Letter No. A1/21476/92

Sub: MMDA - Planning Permission - ~~Construc-~~
~~tion of First Floor residential building~~
~~in Plot No.4 at S.No.86/1A and 1B of~~
~~Ullagaram Village - Approved - Regarding.~~

The proposal received in the reference cited for the
proposed construction of First Floor residential building at
Plot No.4, S.No.86/1A and 1B of Ullagaram Village has been
examined and found approvable.

SITE PLAN. SCALE: 1" = 20'.

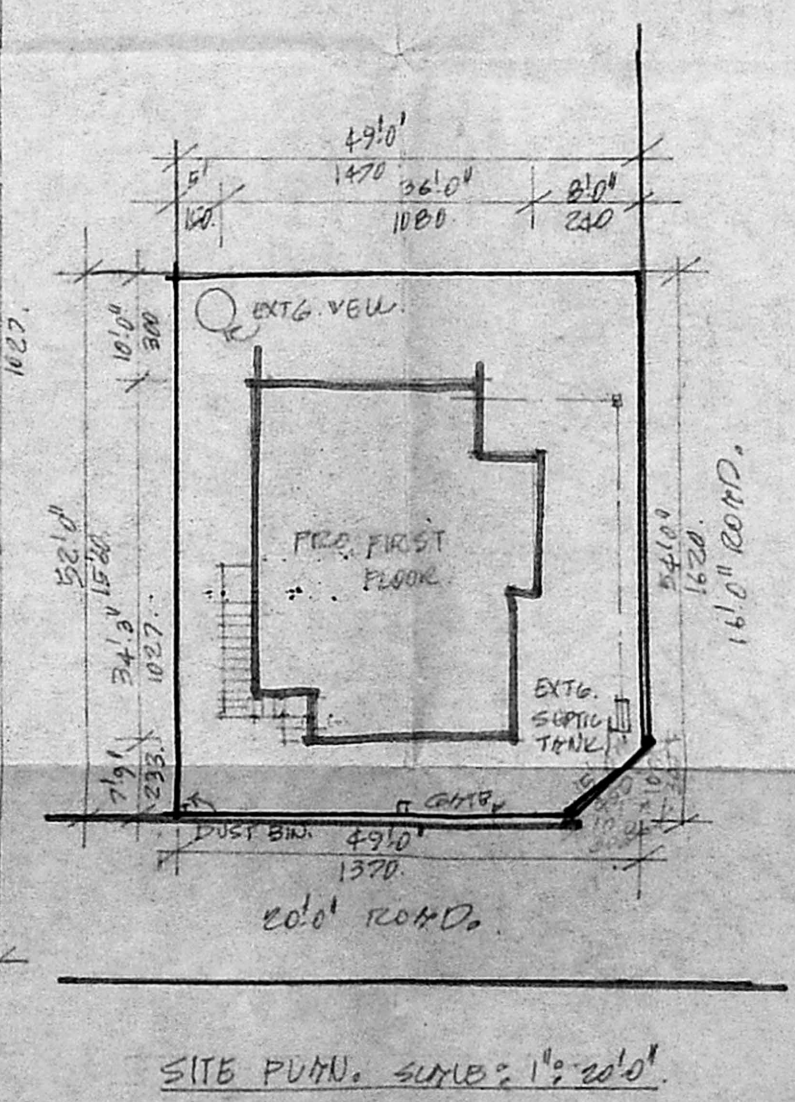
towards Regularisation charge by two separate Demand Drafts
of a Nationalised Bank in Madras City drawn in favour of the
Member-Secretary, MMDA, Madras-8 and pay at MMDA Office Cash
Counter between 10.00 A.M. and 4.00 P.M. within 10 days and
after remit the said amount, you are requested to remit the
duplicate receipt to Area Plans Unit. You are also requested
to submit the Affidavit/Indemnity Bond in Rs.5/- Stamp paper
duly attested by Notary Public. Planning Permission Applica-
tion will be returned unapproved if the amount are not paid
within the stipulated time. You are also requested to furnish
5 sets of revised plan incorporating splay measurements and
without any ink corrections.
